Storm Water Compliance Inspection Form

Date: 08-04-2020

Permit Tracking #: NMR1002FV, NMR1002GI

Owner: Presbyterian Healthcare Services

**EROSION
& SEDIMENT
CONTROL PLAN**

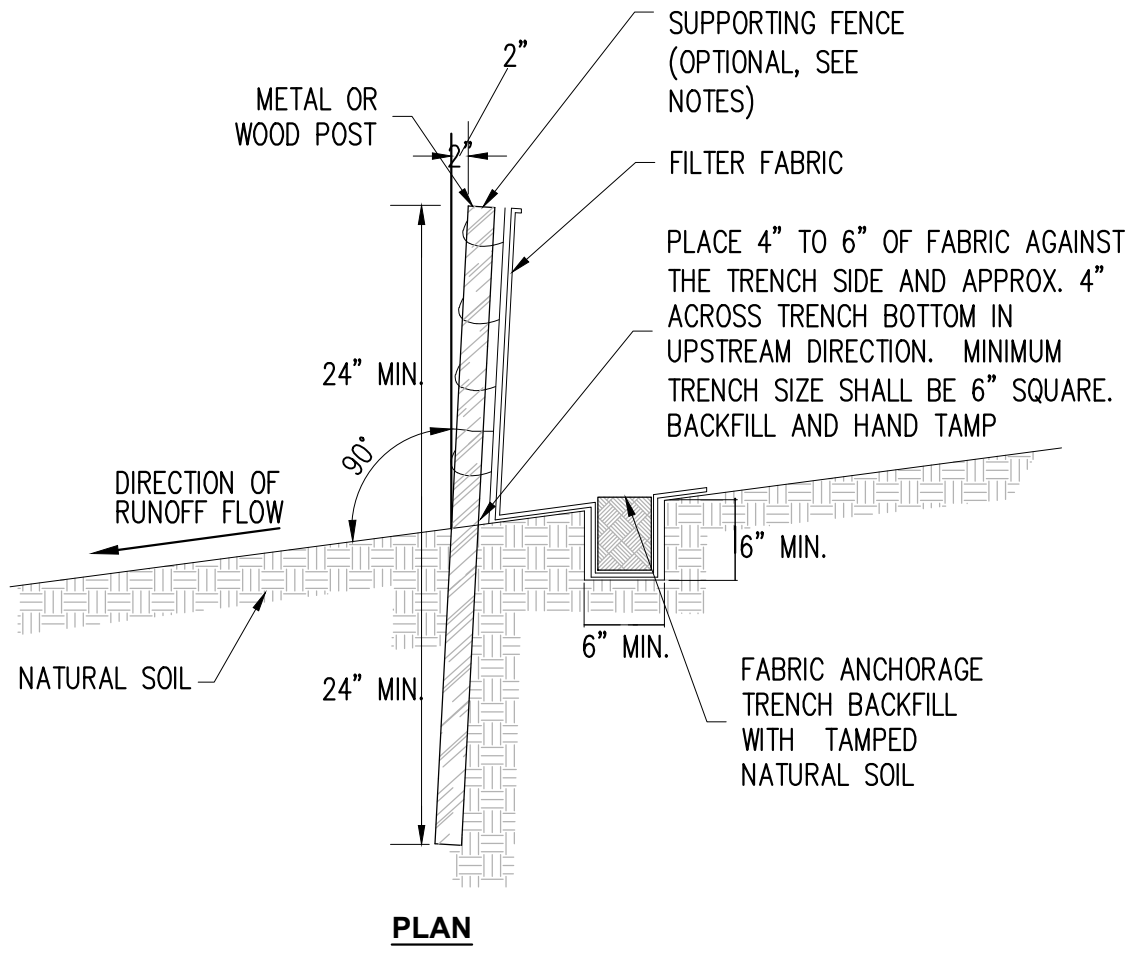
Waste Management	<input checked="" type="checkbox"/>	<input type="checkbox"/>	<input type="checkbox"/>	
Vehicle Tracking Control	<input type="checkbox"/>	<input checked="" type="checkbox"/>	<input type="checkbox"/>	Need to install VTC on both entrances on the west Monitor trackout sweep as necessary Sweeper on site
Material Storage	<input checked="" type="checkbox"/>	<input type="checkbox"/>	<input type="checkbox"/>	
Dust Control	<input checked="" type="checkbox"/>	<input type="checkbox"/>	<input type="checkbox"/>	
Street Sweeping	<input type="checkbox"/>	<input checked="" type="checkbox"/>	<input type="checkbox"/>	
Construction Washouts i.e. Concrete, Paint, Stucco Etc.	<input type="checkbox"/>	<input checked="" type="checkbox"/>	<input type="checkbox"/>	
Discharge Points	<input checked="" type="checkbox"/>	<input type="checkbox"/>	<input type="checkbox"/>	
Sanitary Stations	<input checked="" type="checkbox"/>	<input type="checkbox"/>	<input type="checkbox"/>

Location	Action Type	Action Required	Date Noted	Date Completed	Initials
Inlet Protection - Silver and Oak	Corrective Action	Repair or Replace Filter sock around inlets	07-22-2020		
VTC	Maintenance	VTC needs to be installed on the north west entrance	06-12-2020		
VTC - Silver and Oak	Corrective Action	Need to install VTC/Rock pad at access points	07-22-2020		
Sweep Street - Frontage rd	Corrective Action	Sweep street for heavy trackout. Sweeping was on going while on site.	07-24-2020		
CWO	Corrective Action	Need to pick up CWO spoils around pump and by crane.	08-04-2020
